**ROSEFIELD HEARING**

**EXAMINING AUTHORITY'S SECOND WRITTEN QUESTIONS AND REQUESTS**

**EXQ2**

**ALC REPORT**

Annex 2 – Soil Association Map

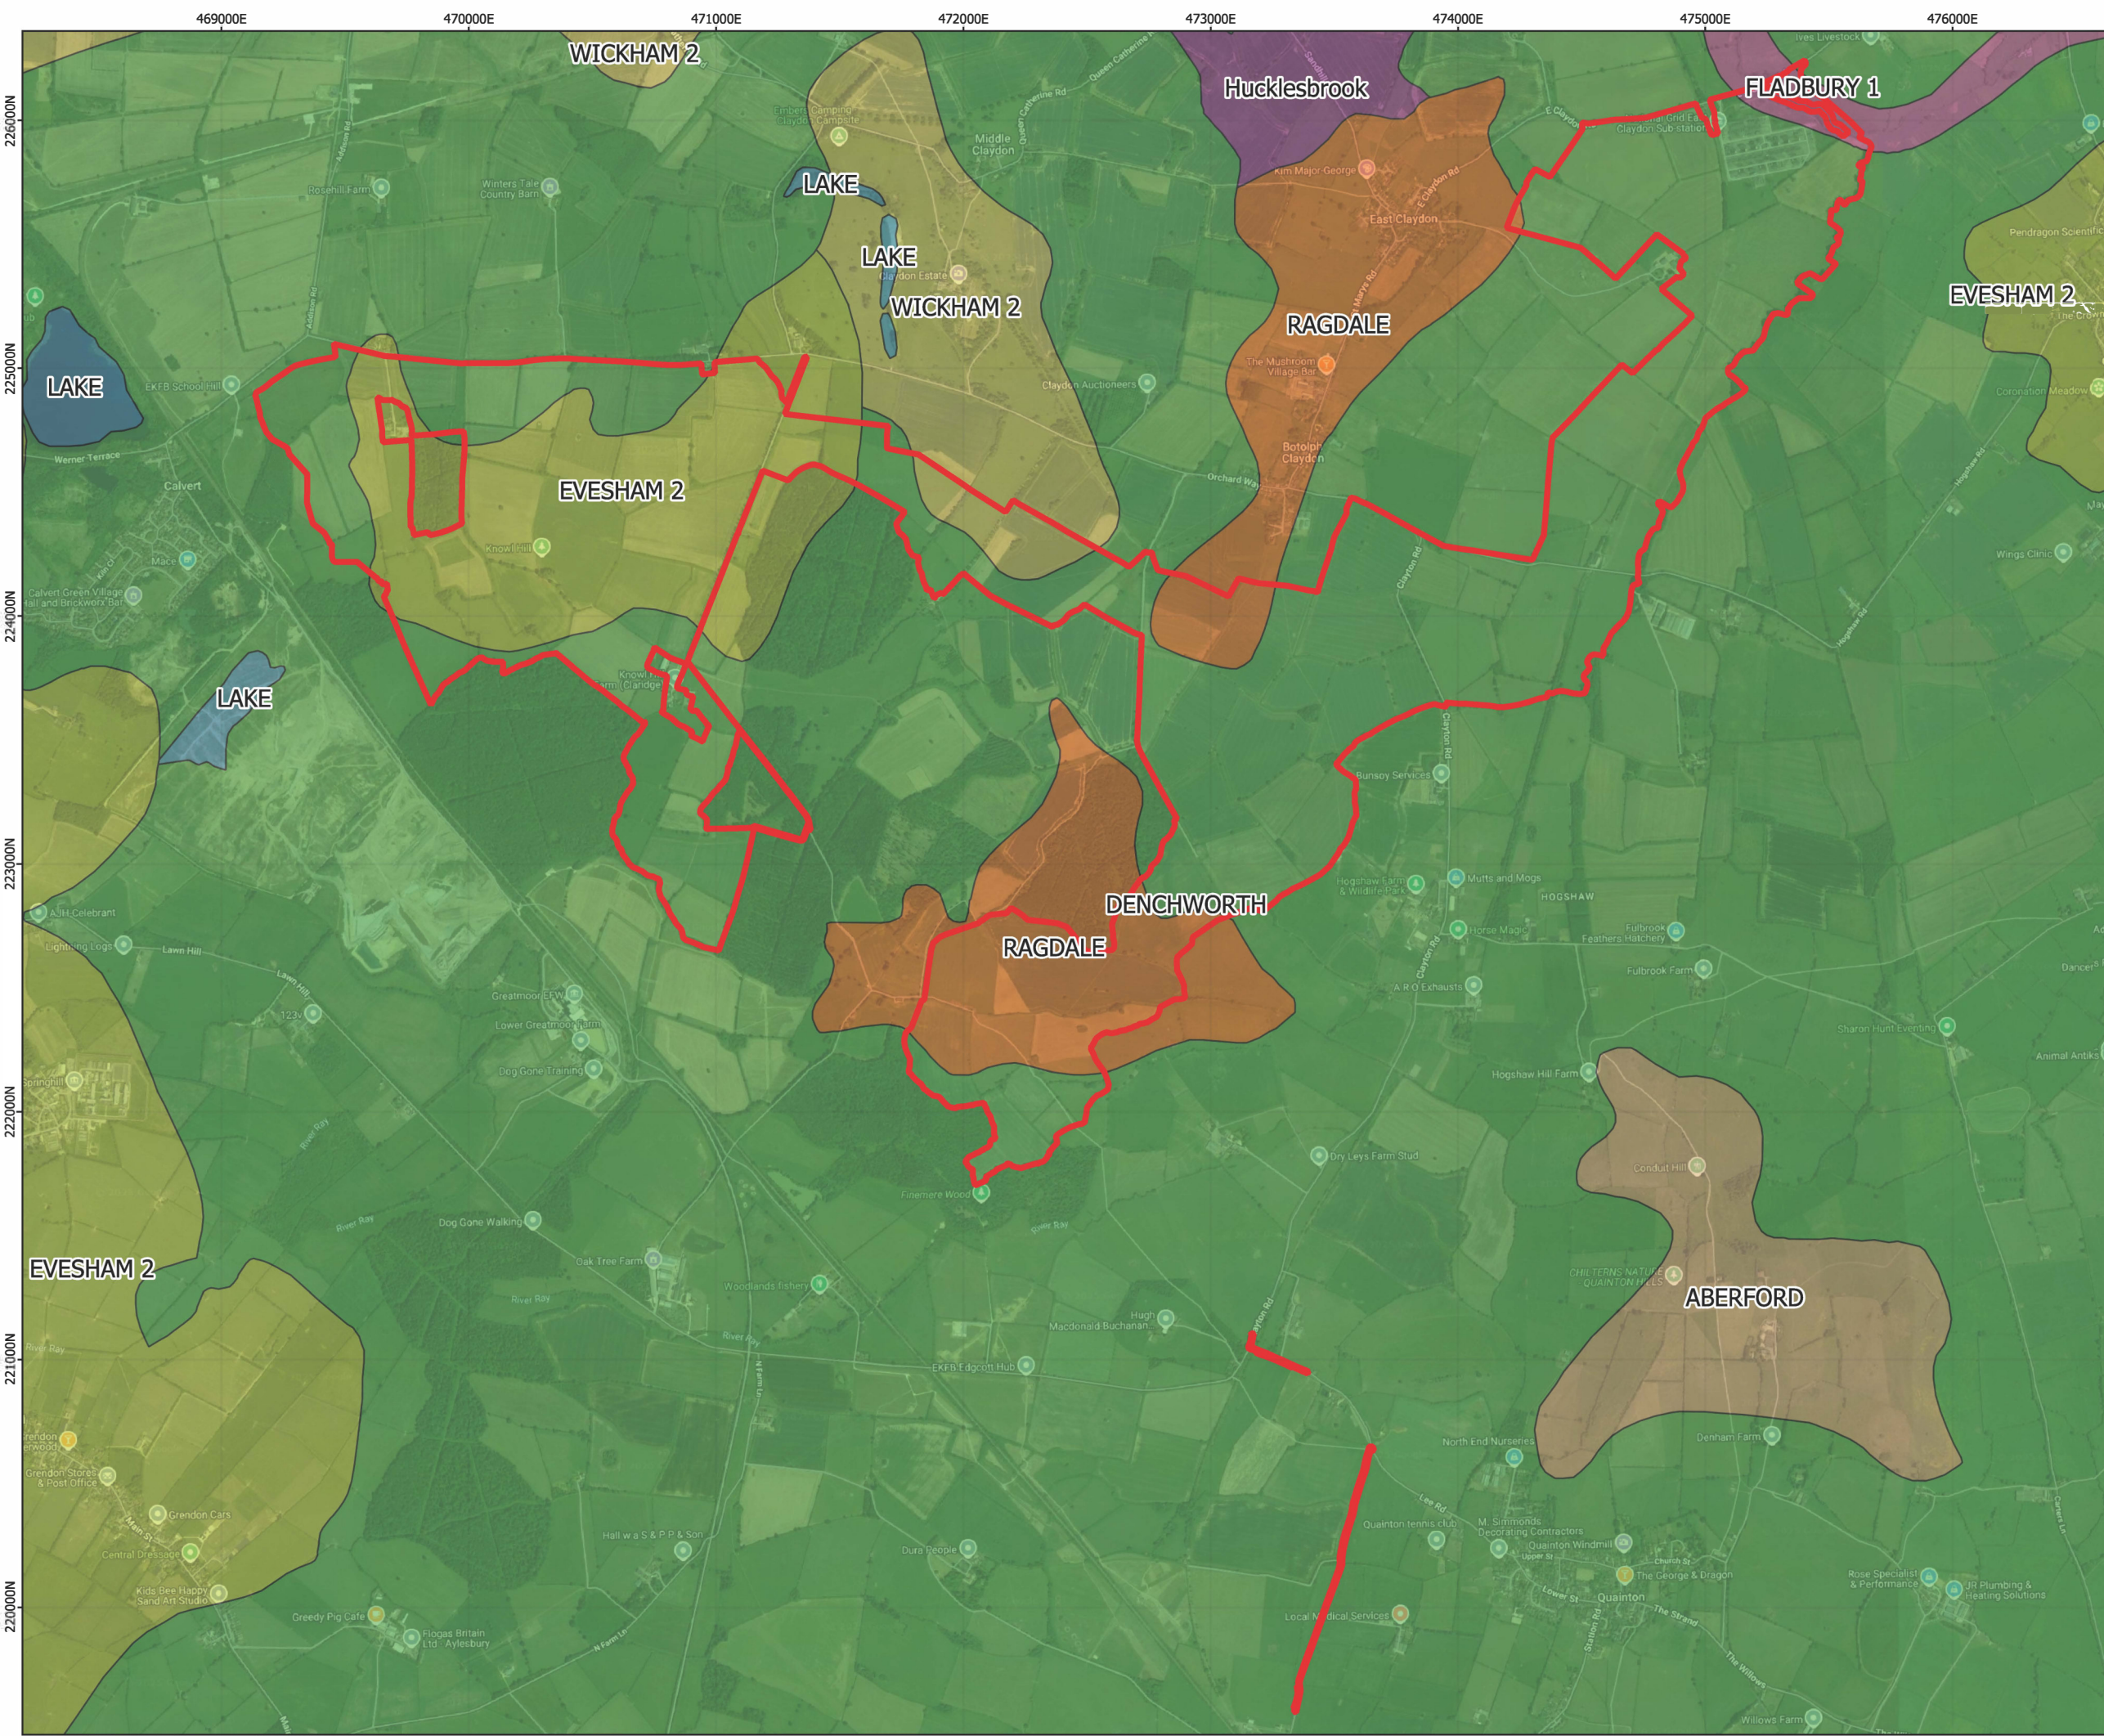
**ANNEX 2 – SOIL ASSOCIATION MAP**

shows our land in light yellow – Allocated Evesham 2

Annex 3a – Auger and Pit Location Map (ADAS)

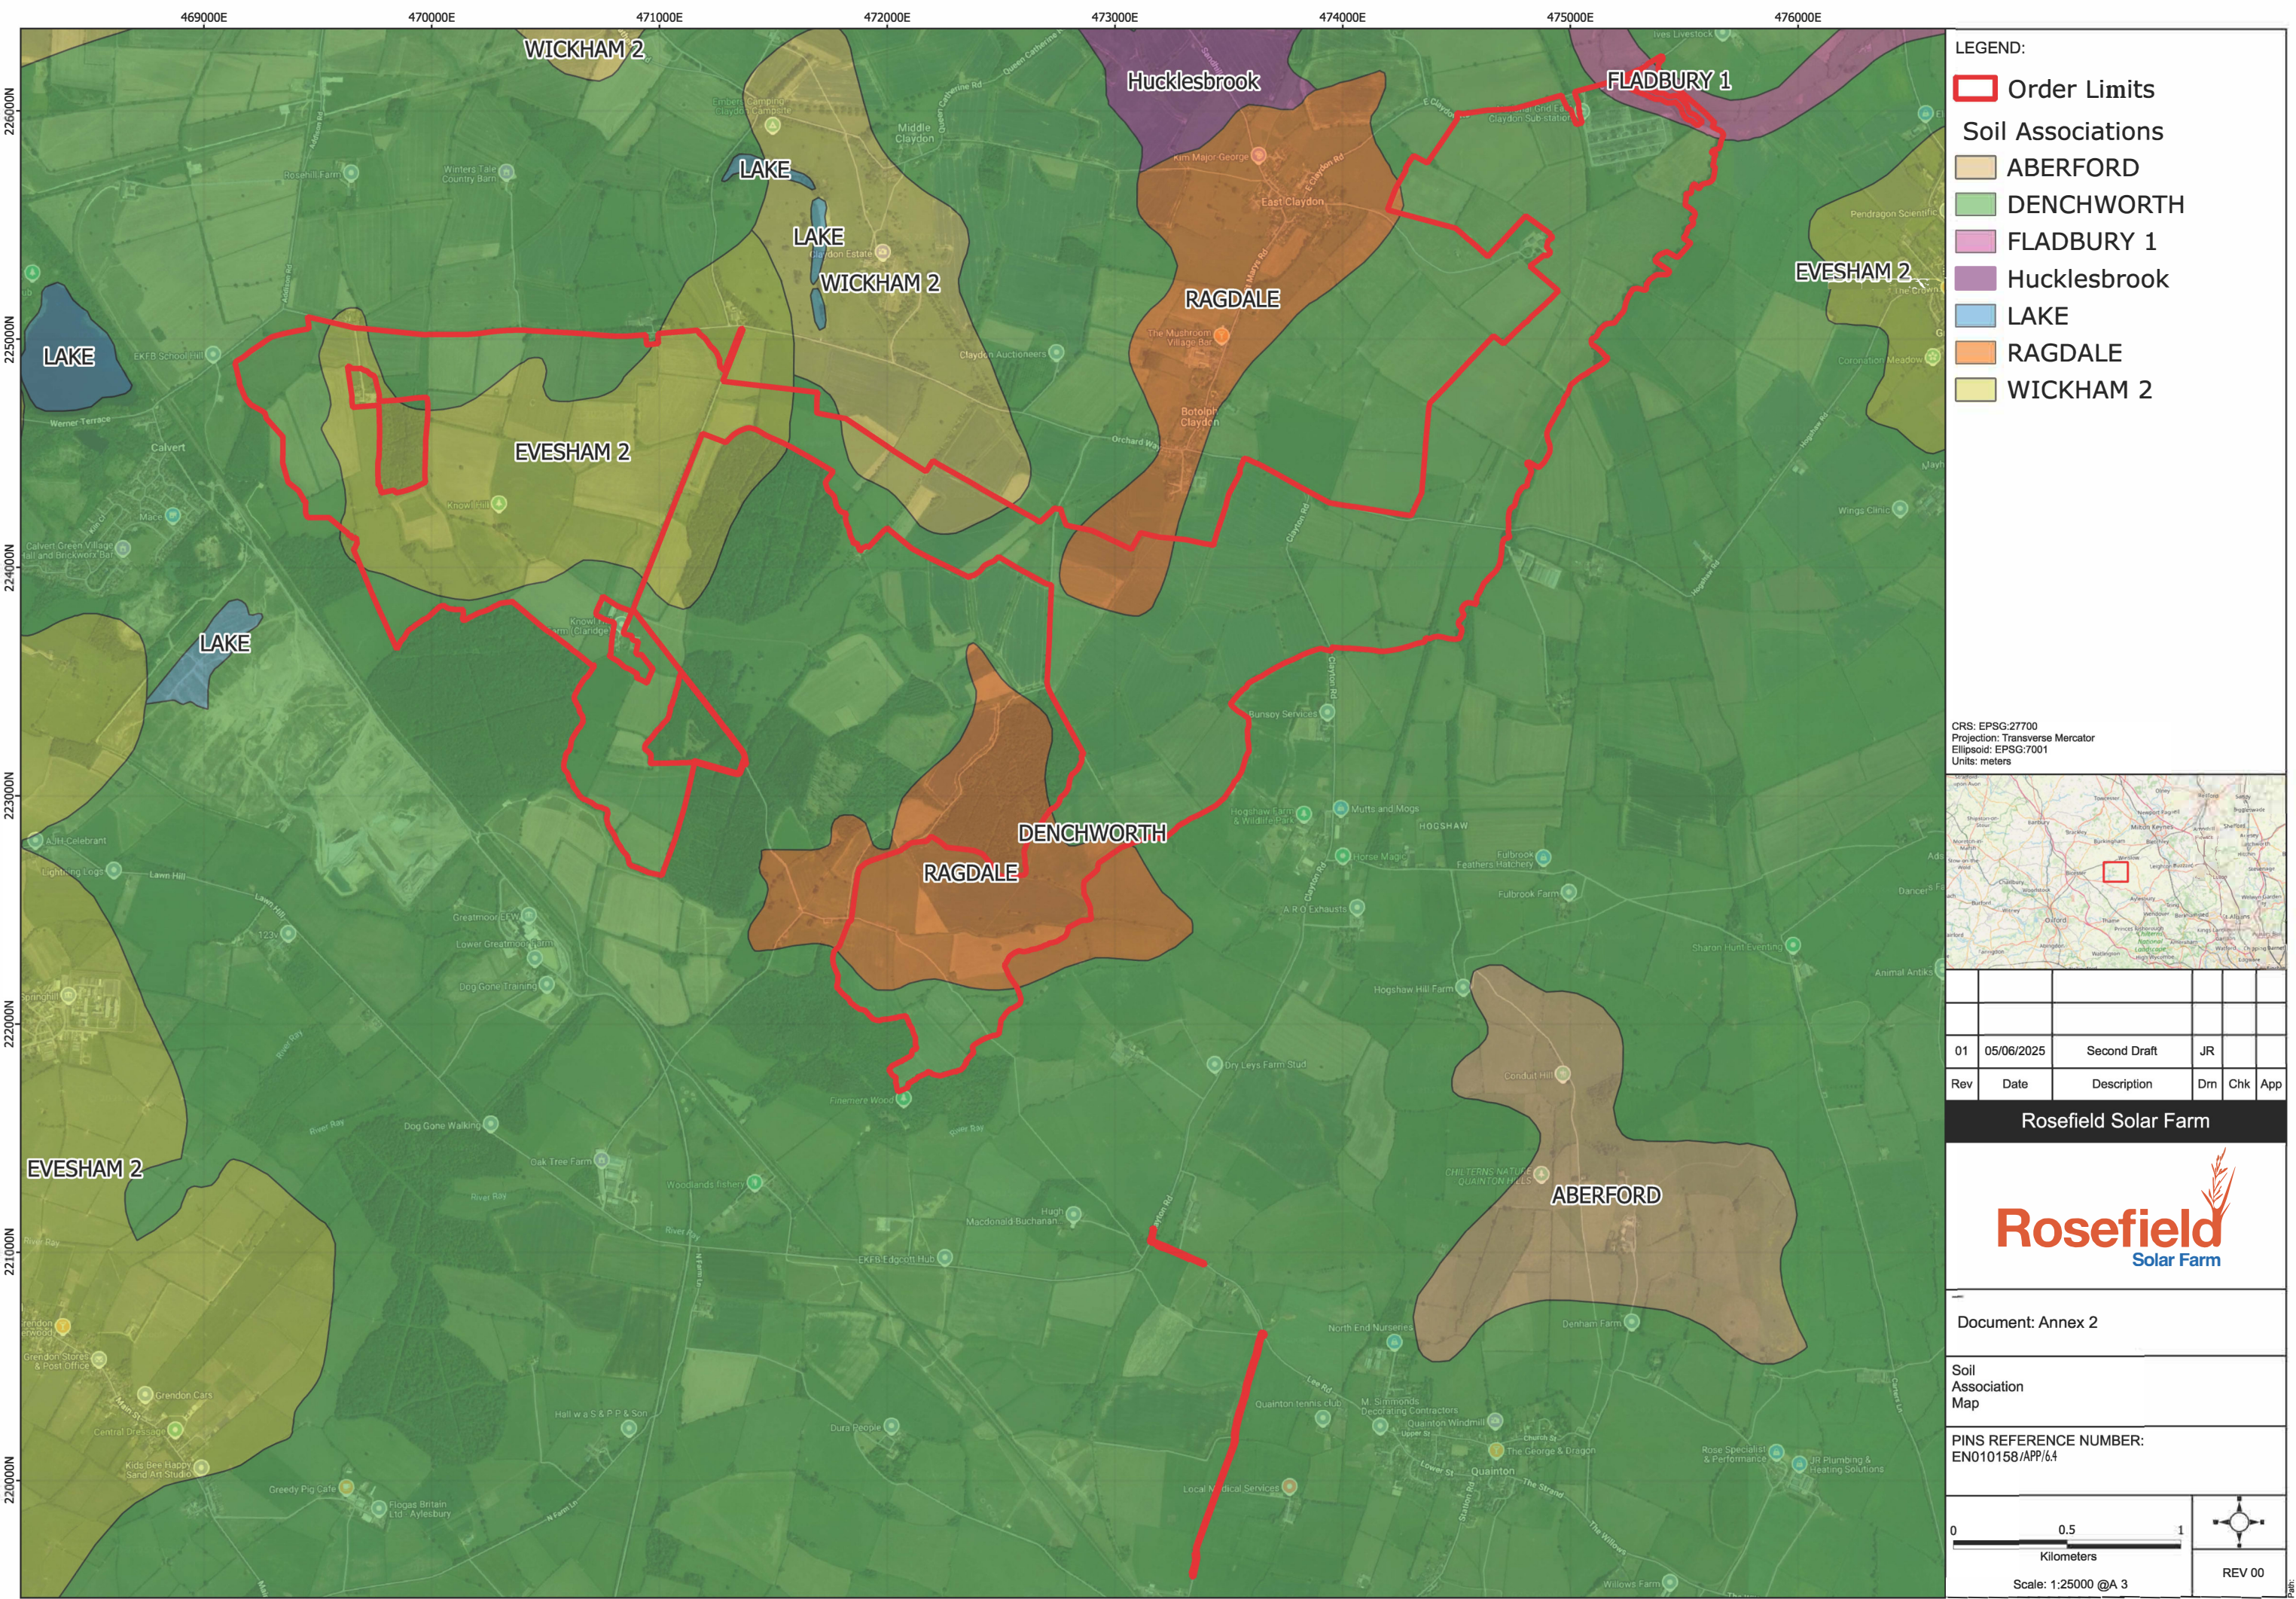
After examination we have some concerns on how the soil results have been logged and allocated as we note that on the parcel of land we are referring to it has a "Soil/Land grade description pit (45)."

It also shows points on our land e.g. 47,52,46, 51 & 64 has having been "auger" tested!

We also note that the Desk Based Study did mention that some land was not able to be surveyed due to Access Restrictions and we do fall under this as **WE HAVE NOT GIVEN ANY PERMISSION TO HAVE ANY INTRUSIVE SURVEY UNDERTAKEN.**

**ANNEX 3A - AUGER AND PIT LOCATION MAP (ADAS)**

shows our land (45) in Light yellow as being Surveyed land!!!

(This we believe this is an untrue statement and misleading)
